# CITY OF ALBUQUERQUE

September 12, 2012

**Re: Plastic Machine Shop Addition, 2601 Baylor Drive SE,  
Traffic Circulation Layout  
Architect's Stamp dated 08-29-12 (M16-D037)**

C3 ADA Curb Ramp
1/4" = 1'-0"

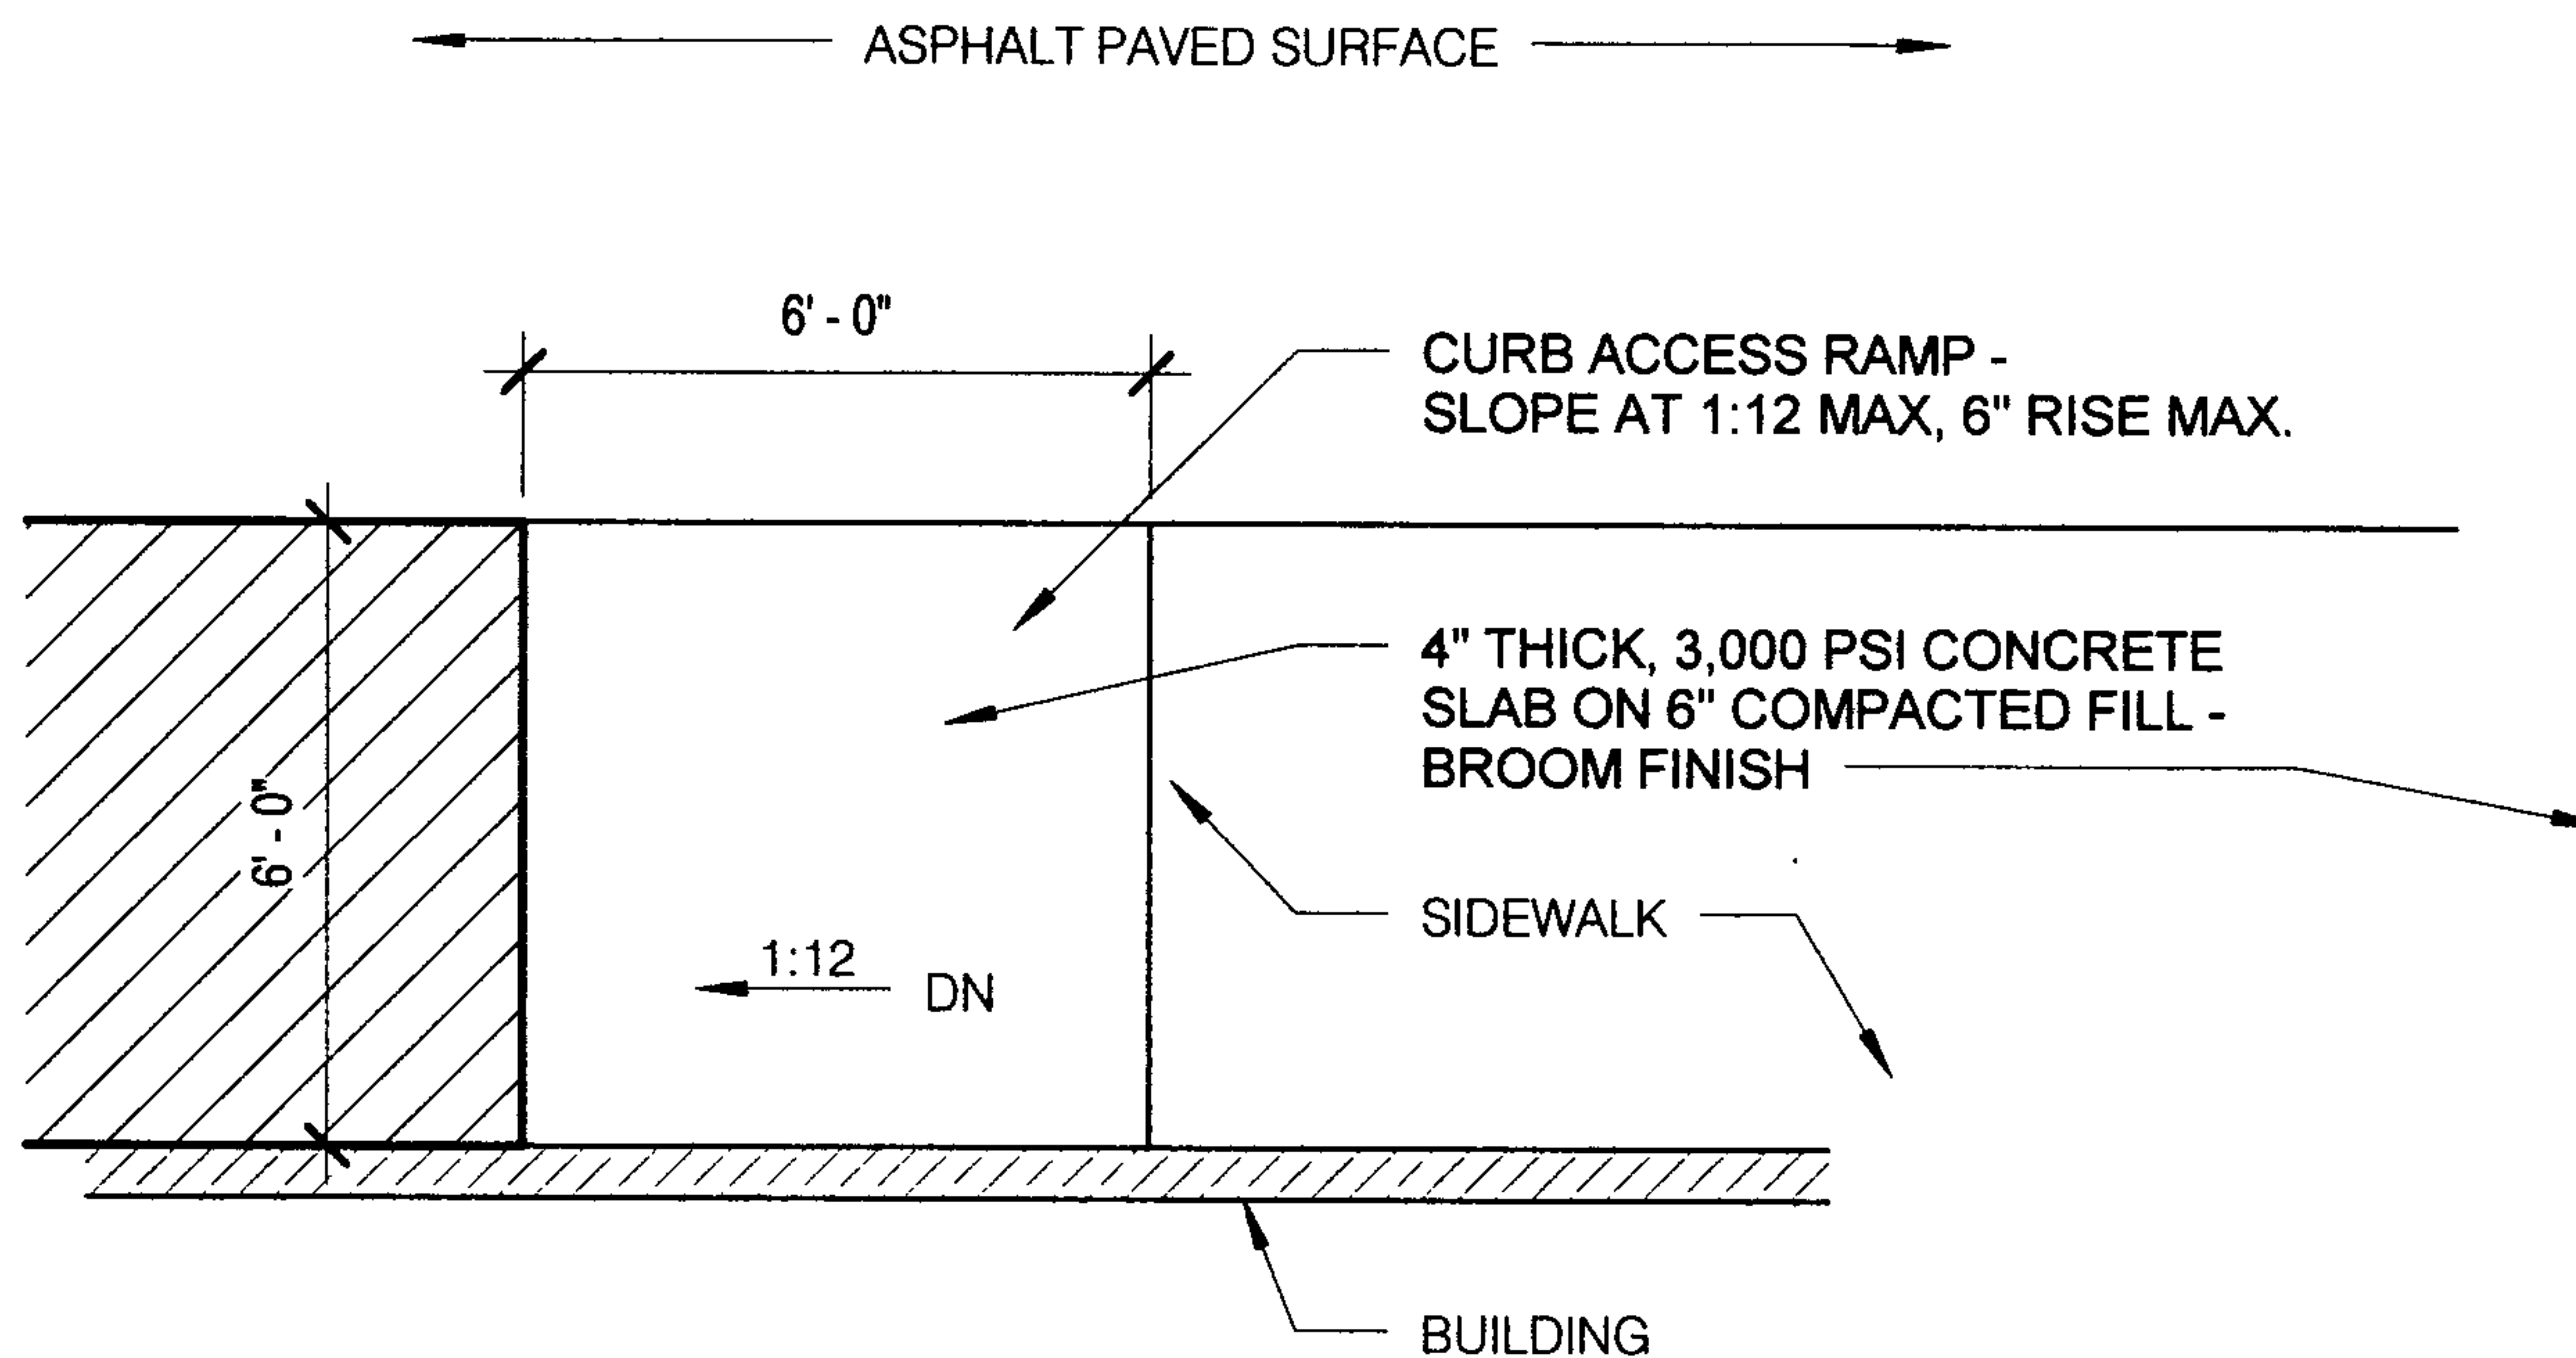
3. The proposed ramp indicated in detail C3 does not provide a 6-foot wide, ADA accessible pathway.
4. The legal description provided does not match what is shown on the plan. Lots 13A, 1D4, and 1D3 must be clearly shown and labeled on the plan.
